**From:** alan.story@hertfordshire.gov.uk  
**Sent:** 07 July 2015 09:06  
**To:** Planning  
**Subject:** Planning application S6/2015/1061/MA - Plot 6000 Hatfield Business Park

**Response to Planning application from Hertfordshire County Council (T and CP GDP Order 2015)**

**District ref:** S6/2015/1061/MA  
**HCC ref:** WH/161/2015  
**HCC received:** 18/06/2015  
**Area manager:** James Dale  
**Case officer:** Alan Story

**Proposal**  
Erection of a private healthcare facility (use Class C2), to include car/cycle parking, boundary treatment, landscaping, lighting and access

REVISION	DATE	BY
Revision A	27.04.15	JE
Footpath access, landscaping and site boundary amended.	01.05.15	JE
Revision B	01.05.15	JE
Revisions to Car Parking and Landscaping.	10.06.15	JE
Revision C	10.06.15	JE
Childcare amended and scale bar added.

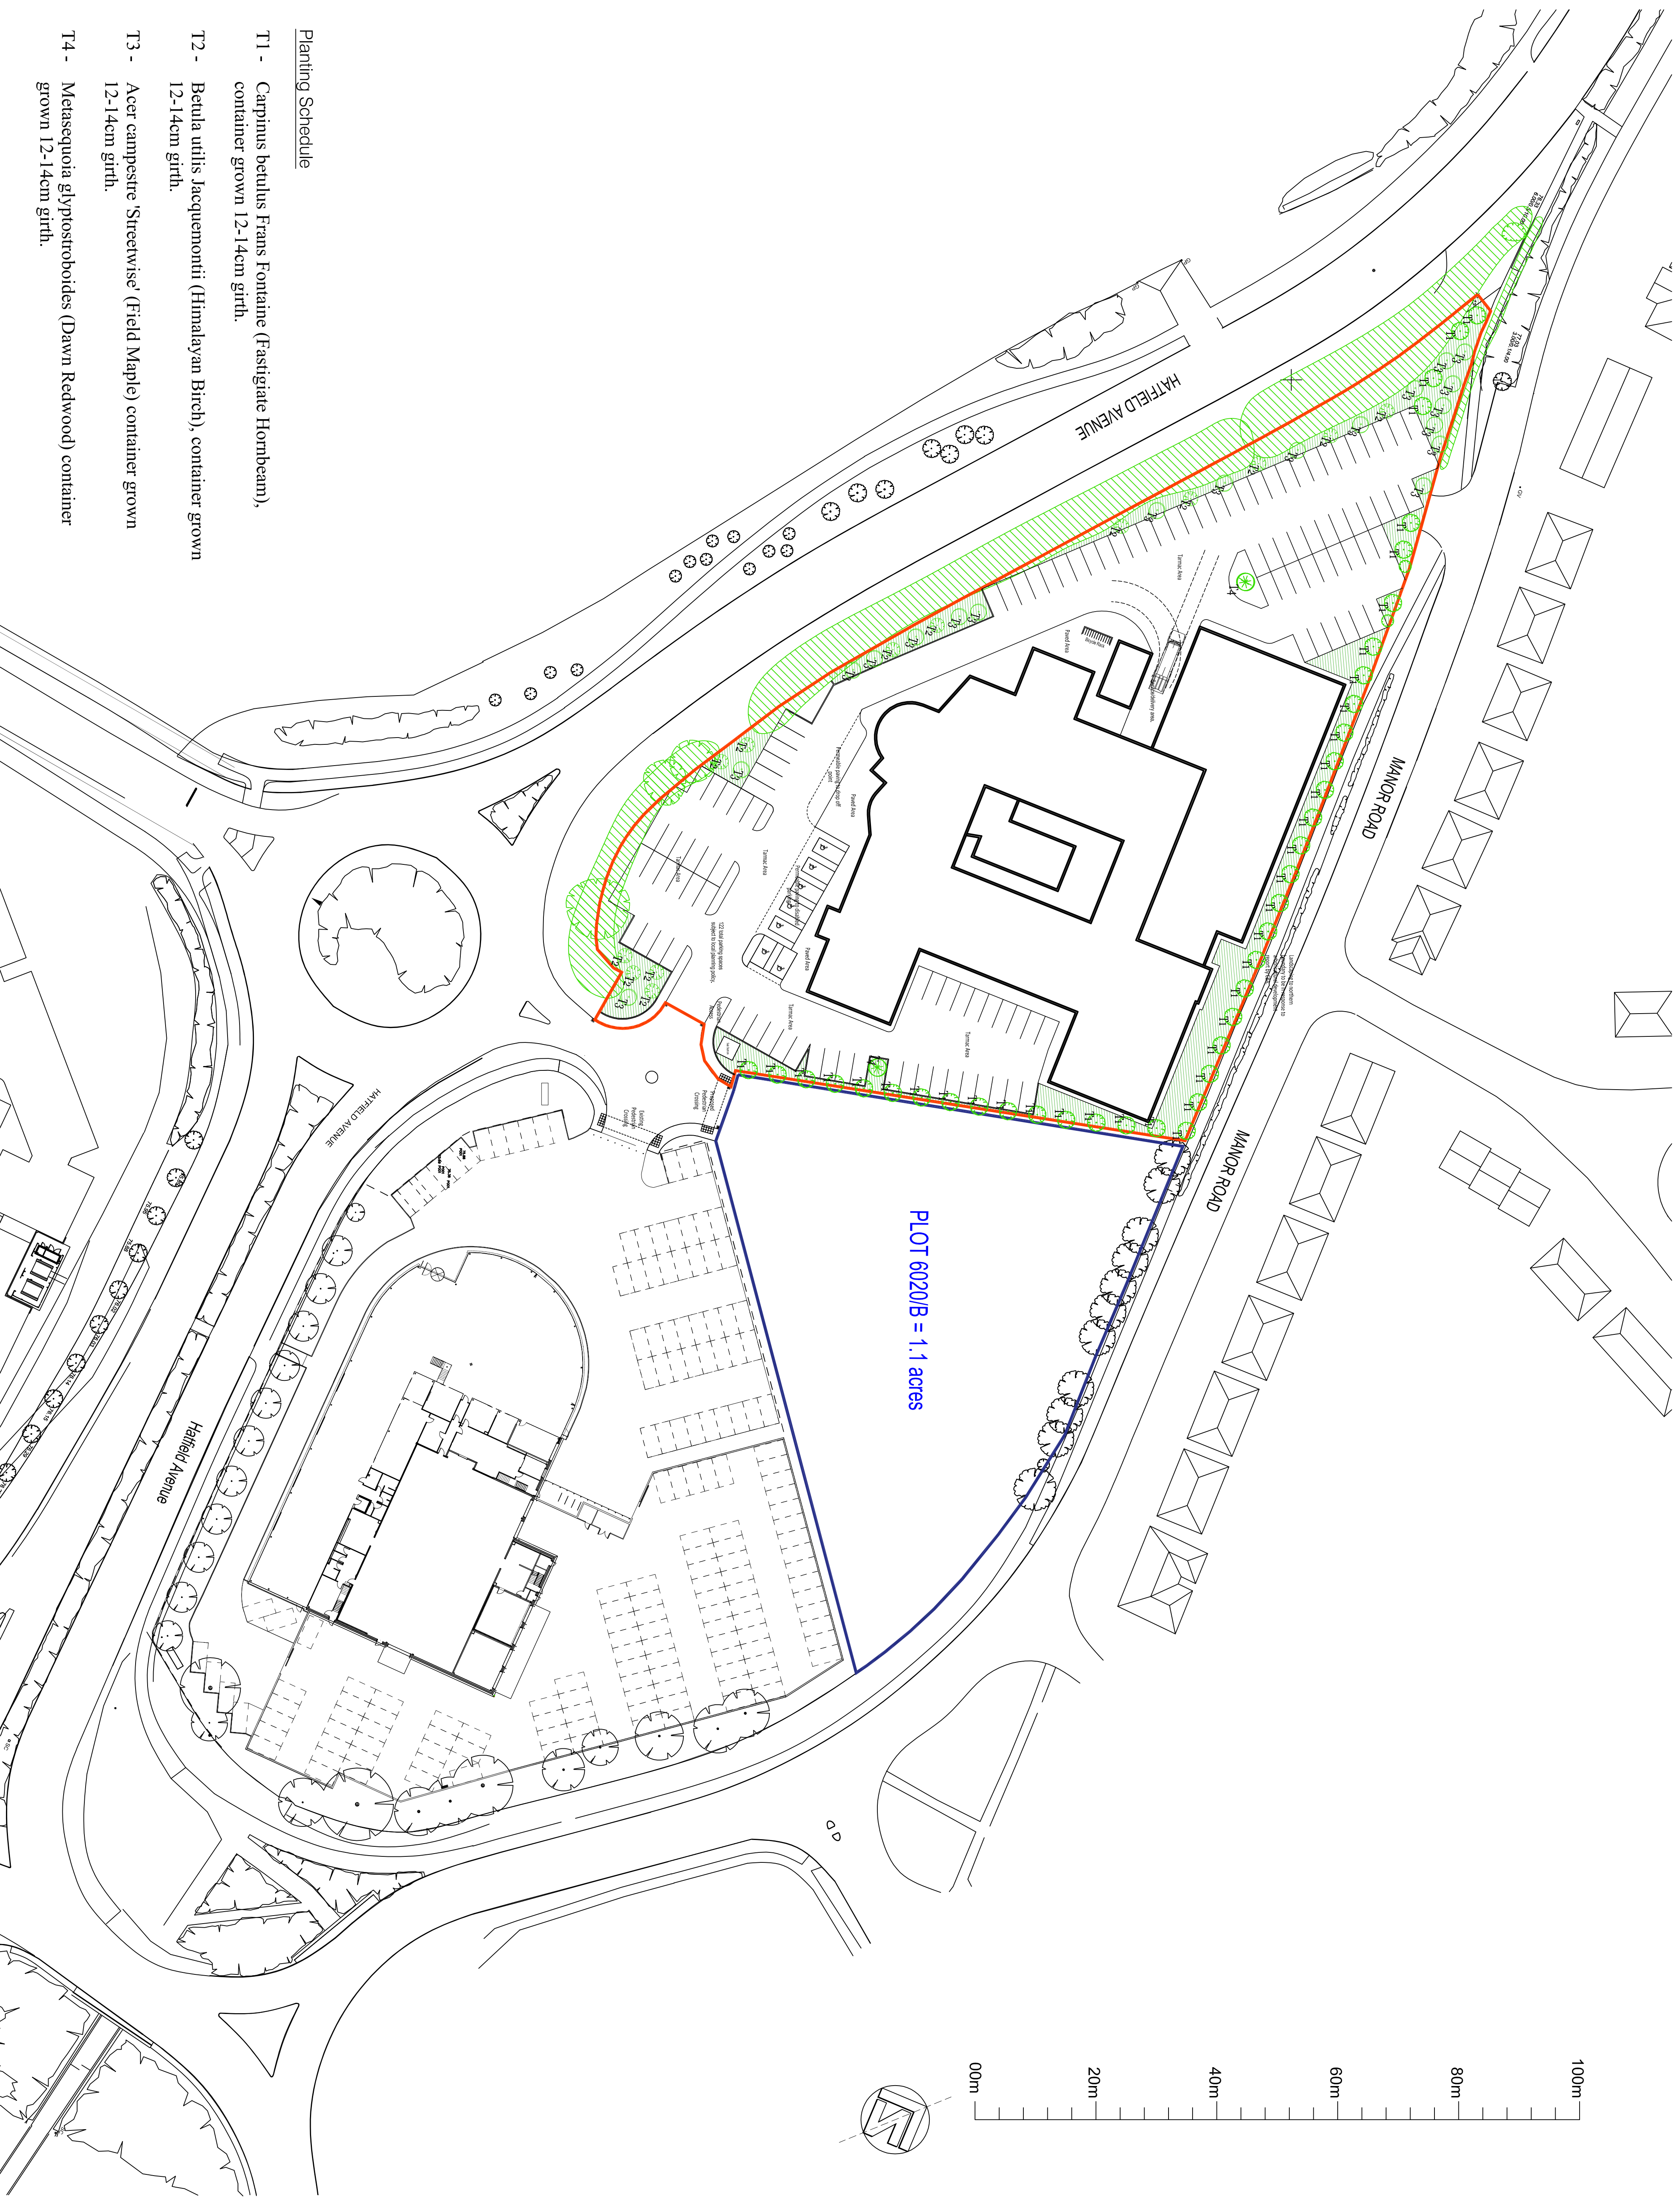
The parking appears to be suitably provided, with spaces to a minimum of 2.4m x 4.8m, however I would highlight that spaces in proximity to the route between parking at front and rear, i.e. eastern boundary, close to the cycle parking facilities adjacent to the stretch of internal route with no parking, appear to only enjoy 5m clear behind (affecting approx. 7 spaces). This would likely result in significant difficulties in entering the spaces.

MfS identifies that a minimum 6m depth is required where bays are 2.4m in width. It is recognised that reductions on this 6m are permissible, where a degree of forward and back manoeuvring is permitted, to access the space, and therefore given this location reasonable to accept, but whether approx. 5m is sufficient should be tested through swept path. Alternatively opportunities to orientate parking in echelon arrangement, or widening carriageway at these points be explored.

I would observe a discrepancy between the TA and application form. The TA (and plans, 1005 PL 202 Rev B) identify 122 parking spaces, however section 10 of the application form suggests only 115 parking spaces to be provided.
